Subject : BR/194/17/PL

Please regard this email as our comments on the revised application from ADC to build a new toilet block and Foreshore Office on Bognor Regis Promenade, opposite Esplanade Grande. ADC's online planning comment process is unnecessarily complex. Please include these comments in the formal process and ensure we receive an acknowledgement.

North Elevation

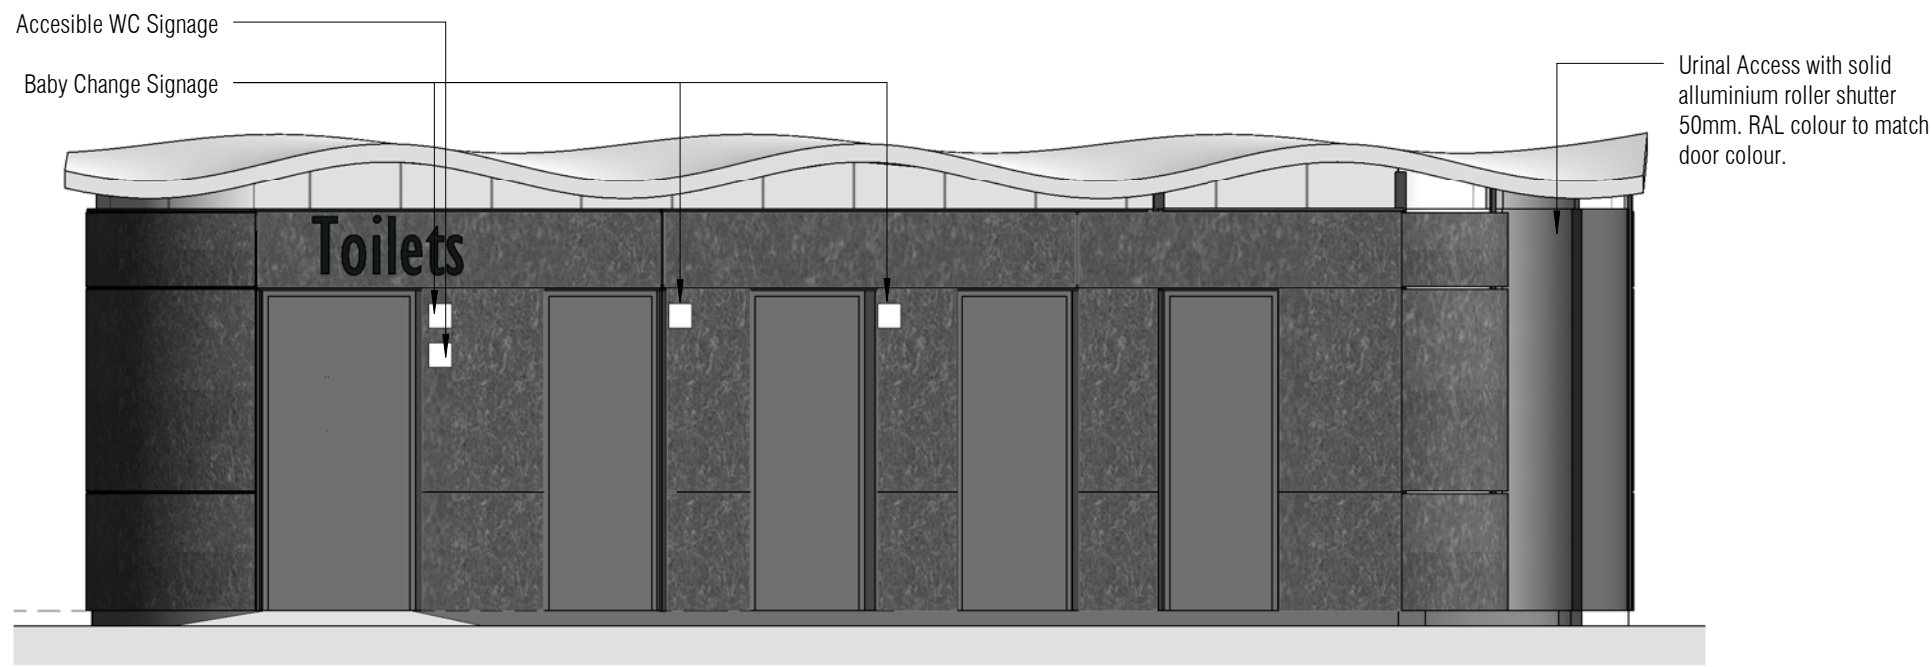
While the revised plans are a considerable improvement in design and orientation, we strongly object to the sign on the North facing side. The plans show TOILET signs at both ends and on the front/seaward side of the toilet block. A sign facing the road is unnecessary as well as offensive to residents in Esplanade Grande. There is also the danger of such a sign distracting drivers and encouraging cars, motor homes and coaches to try to stop and compete for limited parking. These toilets are for Promenade and beach users - not for passing traffic.
